**SUBJECT: WDFW COMMENTS ON RU-24-00001 HORISH REASONABLE USE SV-23-00001
HORISH SHORELINE VARIANCE**

Thank you for the opportunity to comment on the Horish Reasonable Use application for the proposed driveway and subsequent future residence on parcel 516534. The Washington Department of Fish and Wildlife (WDFW) previously provided comments on this project under the Shoreline Variance application (SV-23-00001) which we'd like to incorporate by reference with this letter. The Yakima River is dynamic in this reach with several active side channels and associated wetlands and frequently flooded areas. It's important to recognize these riverine processes to protect them and the functions and values they provide for fish and wildlife in addition to ensuring public safety is considered in and around these Shorelines and Critical Areas.

TO: All Staff
FROM: Public Works Plan Review Team
DATE: April 17, 2024
SUBJECT: RU-24-00001 Horish

Wetland D

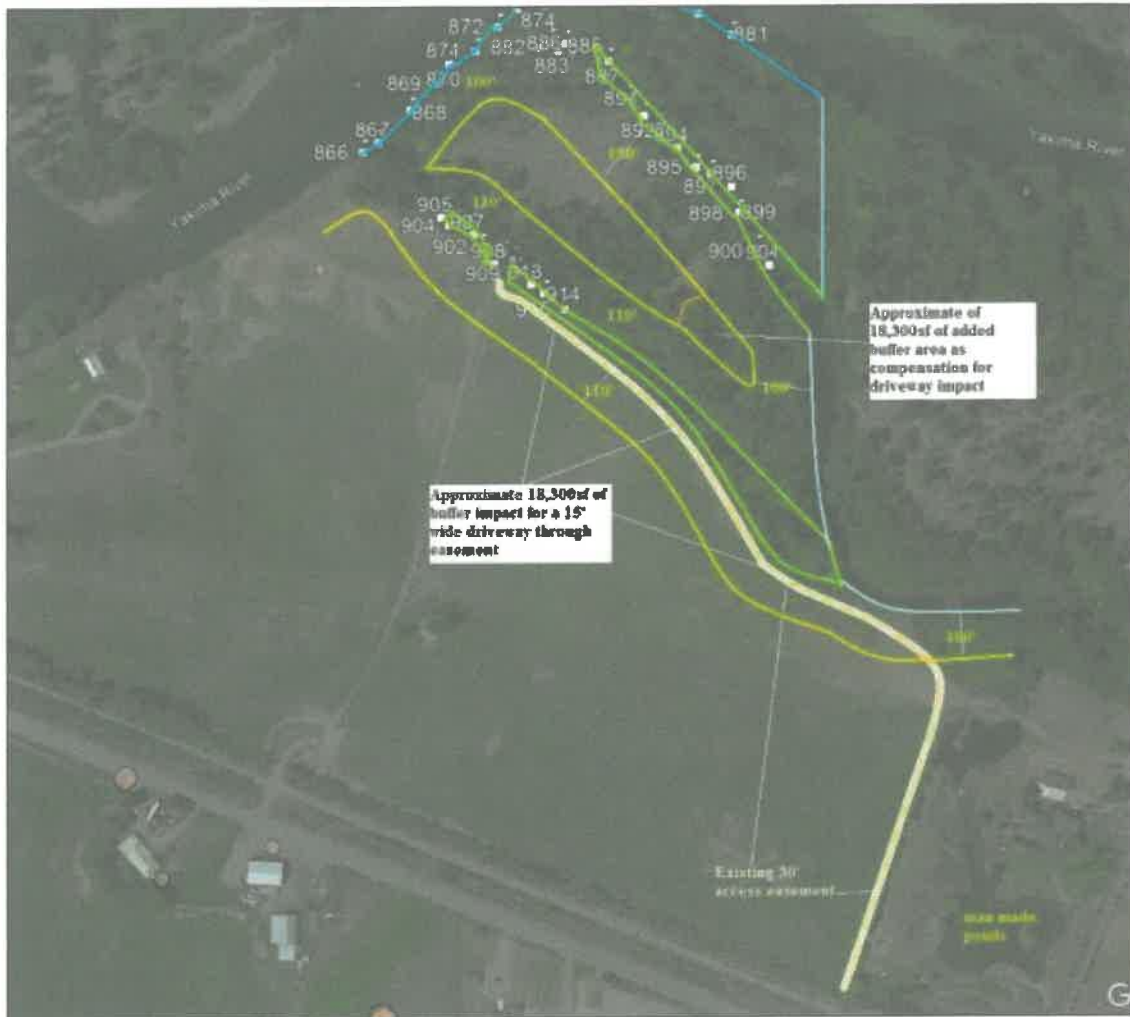
We do not dispute that Wetlands C and D are likely influenced by irrigation practices on the pasture south of them, but they are also hydraulically connected to the mainstem Yakima River as they are relic channel scars within the channel migration zone. These wetlands provide important fish and wildlife habitat as they are directly connected to the Yakima River, just east of the areas shown in the Critical Areas report (Figure 2).

Figure 1: This image comes from Page 9 of the Critical Areas Report submitted with the Horish Reasonable Use application. It clearly shows Wetland D in direct connectivity with the OHWM of a Type S water near the bottom right of this image.

### Proposed Access Driveway

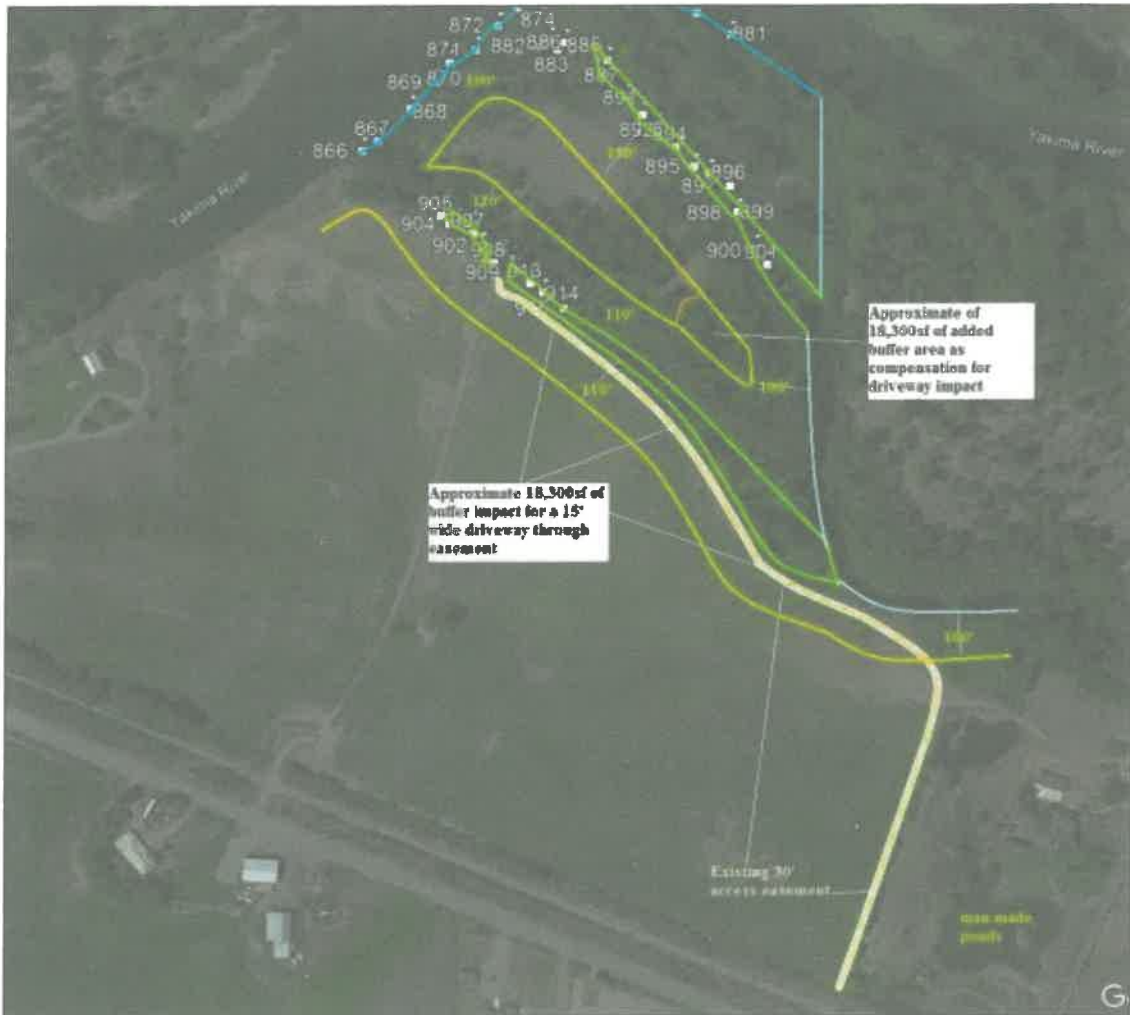
It is our understanding that Ms. Horish recently willingly relocated the existing easement across parcel 546534 to access parcel 516534. The new easement location results in the need for a new driveway that follows the terrace edge of the Yakima River floodplain and its associated side channels and wetlands; thereby creating a need for additional mitigation and potential variances from existing code. The proposed driveway falls within the buffer requirements for the Shoreline Master Program (KCC 17B) as the wetlands are in direct connectivity with side channels of the Yakima River. **The Reasonable Use considerations under the Critical Areas Code (KCC 17A) are helpful for considering impacts, but KCC 17A is not applicable in this location for this project and we recommend reconsideration of the Shoreline Variance as originally proposed.**

Driveway to meet the requirements of the International Fire Code (IFC) including Appendix D.
